From: Holly Duncan
Sent: Tuesday, October 04, 2011 3:57 PM
To: Jeff Watson
Subject: RE: BL-11-00024 Otte

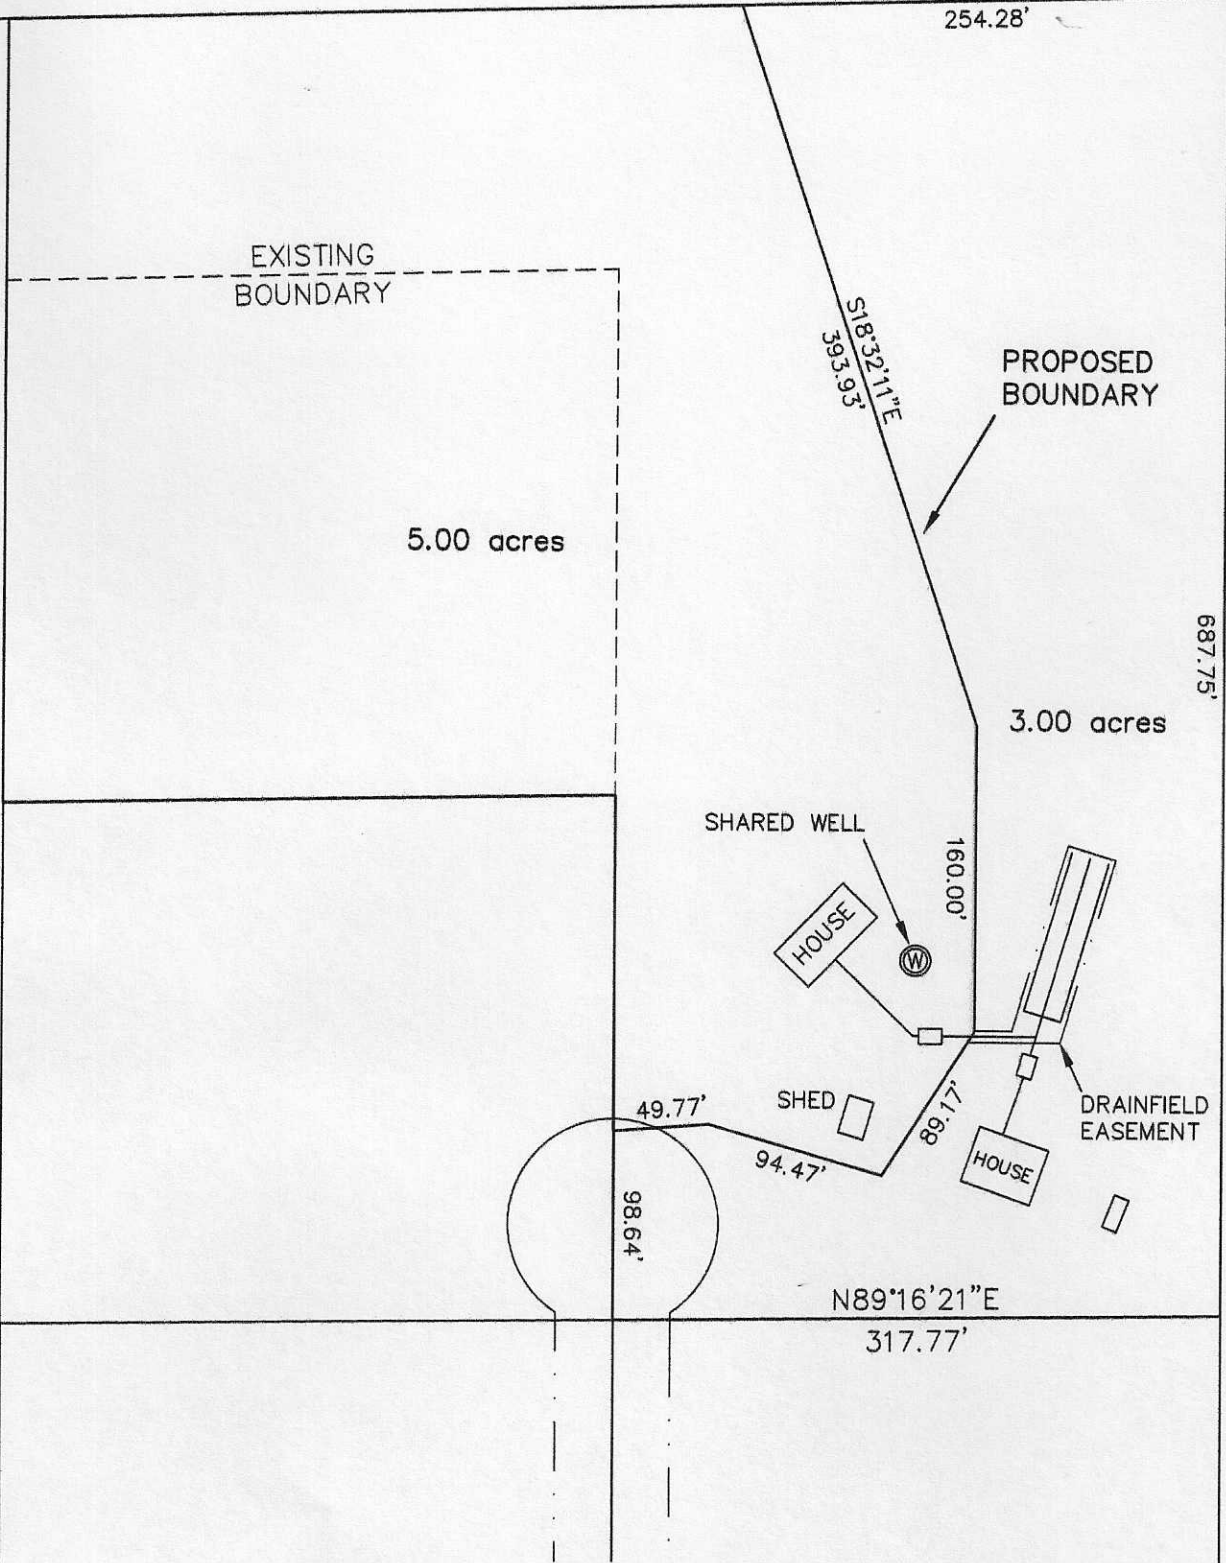
I also have questions on this one. It appears that the proposed project will have a lot line going through the area where the house, well site and drainfield might be. I need a better site plan showing the location of the well and on-site sewage system in relation to the proposed lot line. Can the applicant provide this?
